Wroxton Motocross Application 21/00517/F

Dr Charlotte Watkins, Ecology Officer

Figure 6 Landscaping plan, existing and proposed features

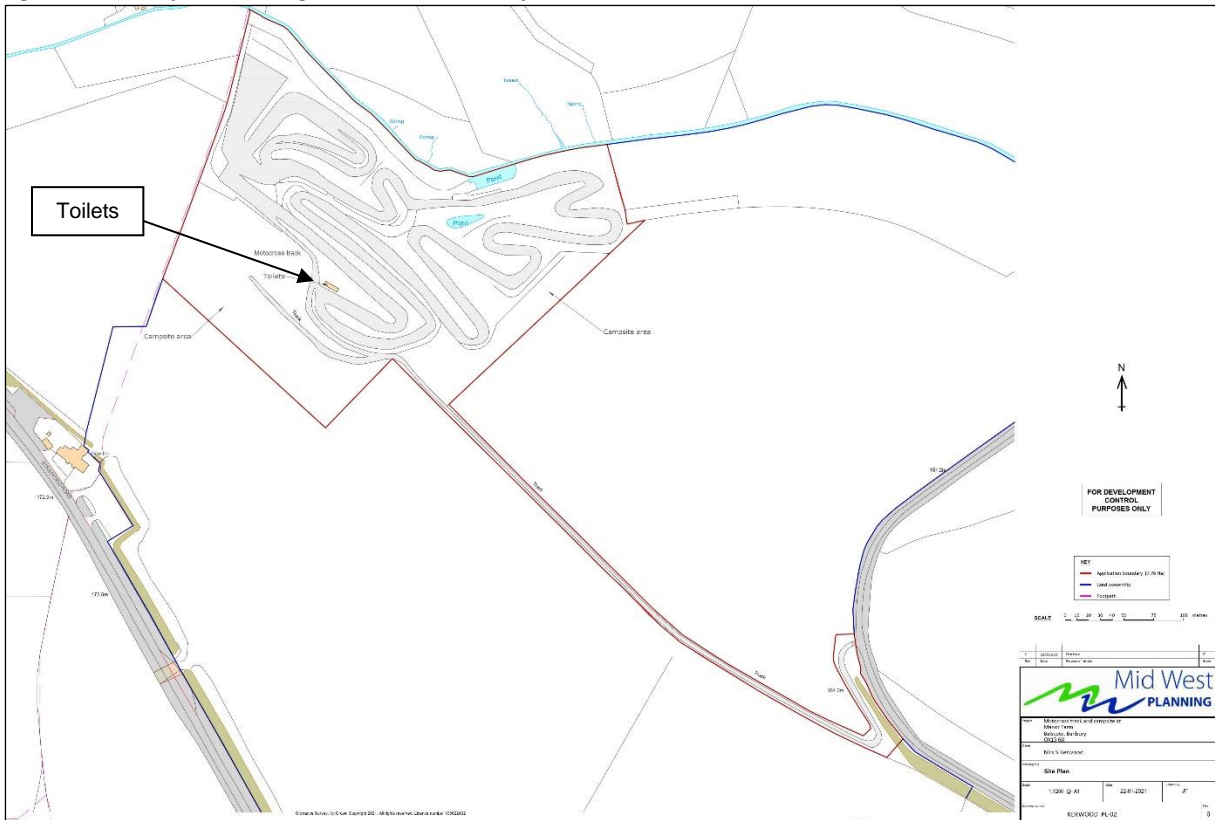
There are some landscaping issues remaining and I would hope these can be resolved within an agreed LEMP. The biodiversity metric submitted is generally fine however it does not include the current ponds in the baseline habitats and I think is proposing that the ephemeral patches of grass in between the track will be enhanced to dry acid grassland of good condition? Which seems unlikely? (– if I have this confused then please do correct me). If carried out as written it would demonstrate a reasonable net gain is possible although this will heavily depend on the management of the habitats and operational procedures employed on site including the level of usage by vehicles, dealing with waste and run-off all of which should be within a pre-commencement LEMP. Any LEMP should include monitoring to ensure there are regular checks by an ecologist so adjustments can be made to management of habitats as required. Where habitats do not reach the proposed condition there may need to be additional measures taken in the future to ensure a good net gain is reached.

My concern is the feasibility of what they propose. Even with the current level of usage of the track aerial photography shows the track and earthworks extend well into the area they propose to now be heathland, grassland and tree planting. The ponds on site also look very squeezed when the track is looked at in its current reality. Once the usage is increased significantly I think they will find it very difficult to create and retain the habitats they propose in these areas (see comparison below of intention and how the track looks in our latest AP information).
